TO:	Arun District Council - FAO: Simon Davis
FROM:	WSCC - Highways Authority
DATE:	22 June 2021
LOCATION:	Land Rear Of 1 Northfields Cottages, Fontwell Avenue, Eastergate, PO20 3RX
SUBJECT:	BN/54/21/DOC Approval of details reserved by condition imposed under ref BN/50/20/PL relating to Condition Nos 5 - mitigation method statement, 6 - archaeology, 7 - piling risk assessment & method statement, 8 - Construction & Environmental Management Plan, 9 - foul drainage, 10 - surface water drainage, 11 - maintenance & management of surface water drainage, 13 - pre-commencement site meeting, 15 - odour assessment or evidence that livery has ceased, 16 - soil resource plan, 17 - landscaping, 18 - screen walls & fences, 19 - elevation details of 2 proposed communal bin stores and 20 - colour schedule of materials & finishes.
RECOMMENDATION:	No Objection

West Sussex County Council, in its capacity as Local Highway Authority (LHA), have been re-consulted on discharge of conditions attached to approval BN/50/20 (42 x dwellings). In comments dated 27 May 2021 further information was requested for condition 8, Construction and Environmental Management Plan (CEMP).

SITE COMPOUND LAYOUT - EASTERGATE

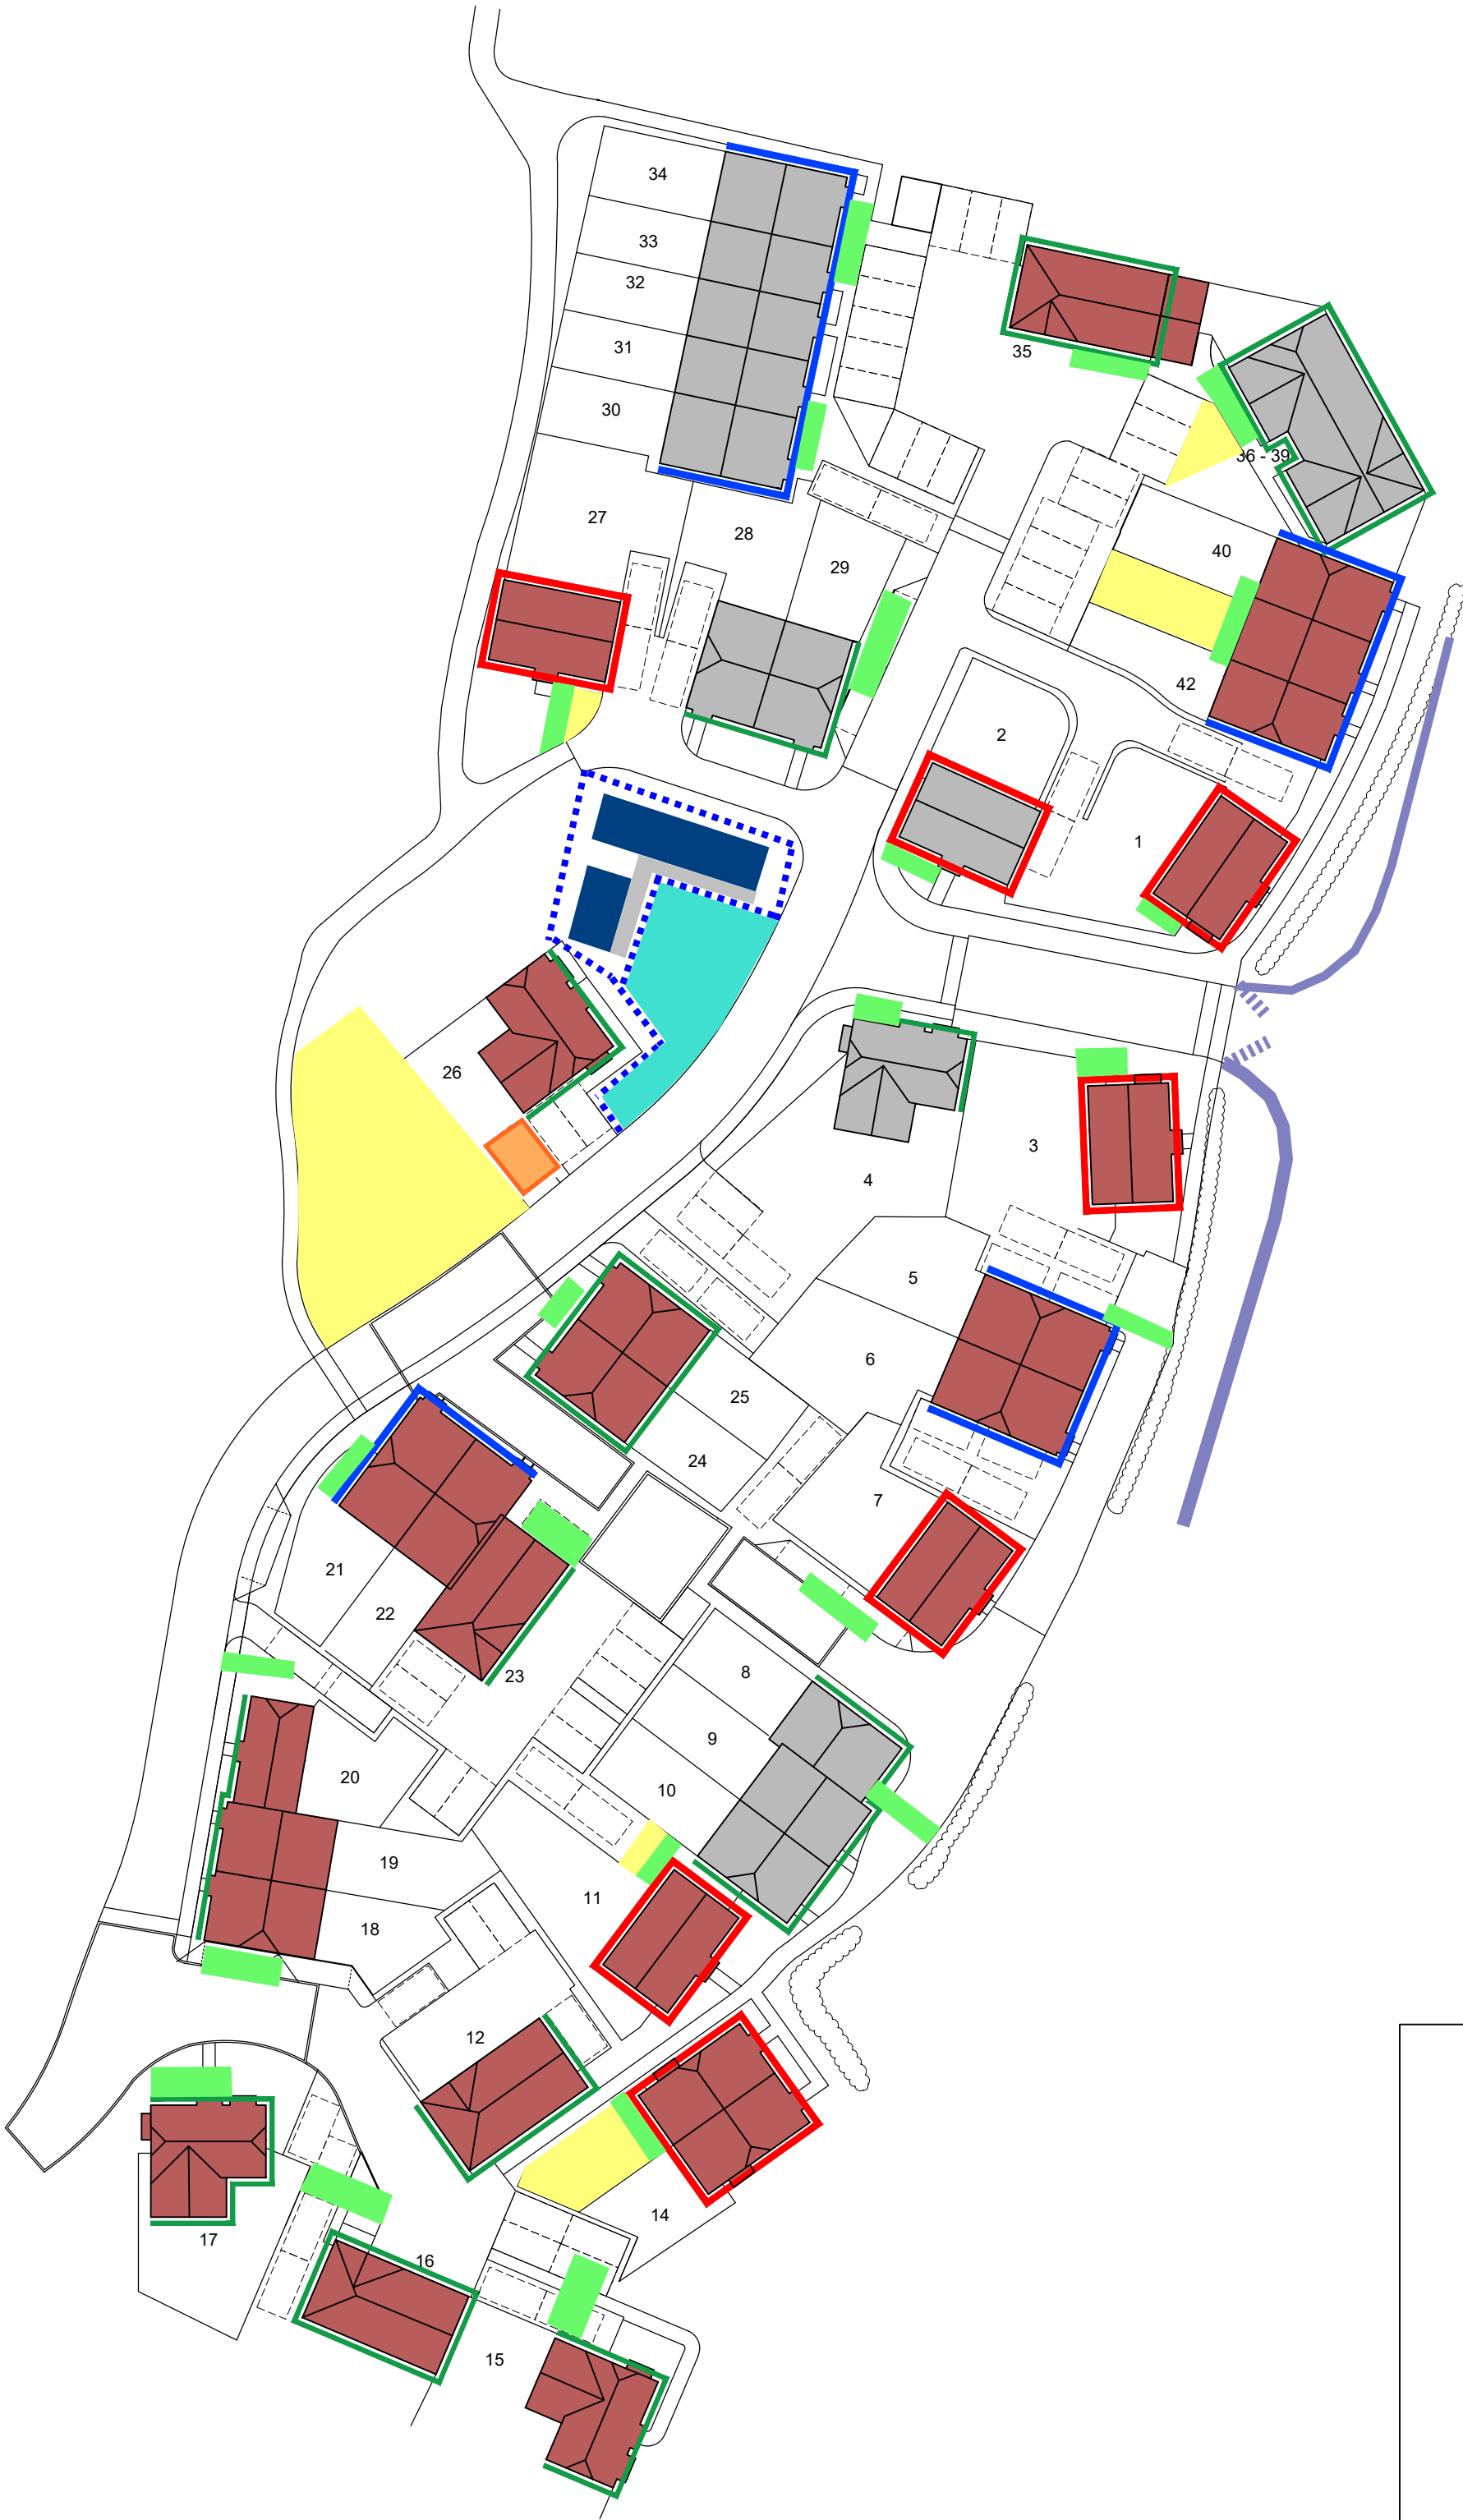
A Site Layout Plan has been provided showing areas for parking, loading/unloading and material storage. Close boarded hoarding is shown at the entrance point, this should not enclose the public highway. Whilst wheel wash has not been indicated on the plan, the CEMP refers to this being provided at site exit if required.

There is a current s278 application for the highway/access works. The applicant should discuss with the engineer reviewing the application that the proposed stage of construction access is suitable for construction traffic.

The plans and details pertaining to condition 8 are acceptable.
